## Application for a Non-Material Amendment Following a Grant of Planning Permission

Notice Of Approval May 23 2022 Application Number NE/22/00686/FUL

Location Five Spires Church Green Woodford Kettering Northants NN144EU

Front and rear ground floor extensions; New Entrance Porch: Addition Of Solar Panels to the south west elevation: Change to Fenestration and Rendering Revised submission NE/22/00016/FUL

Drawing Title:
Proposed Floor & Roof Plans

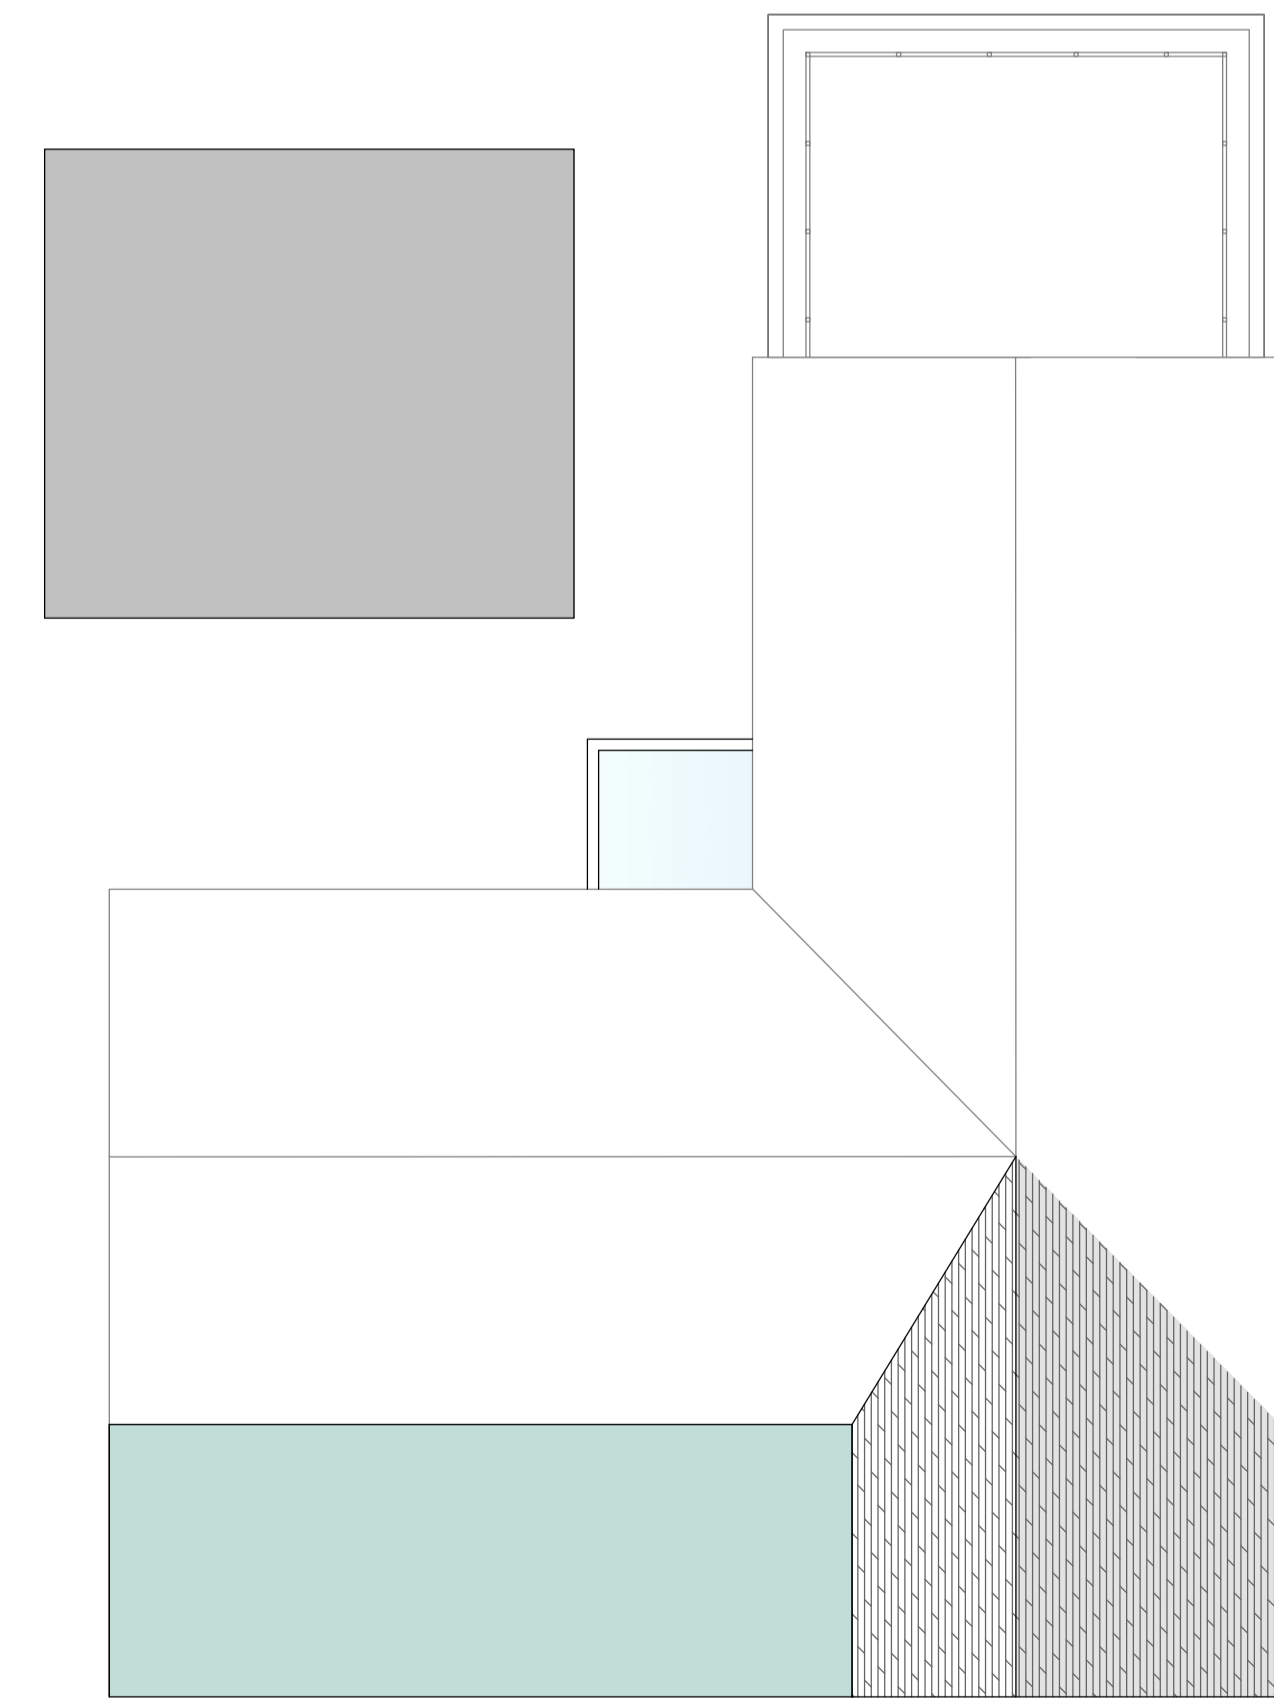
Reduce the size of the Extension from 27Sqm to 15Sqm

Extension to be Flat roof

Keep existing internal walls

Keep existing Roof and Tiles

Reduce the size of front Porch

Reduce Size of entrance steps
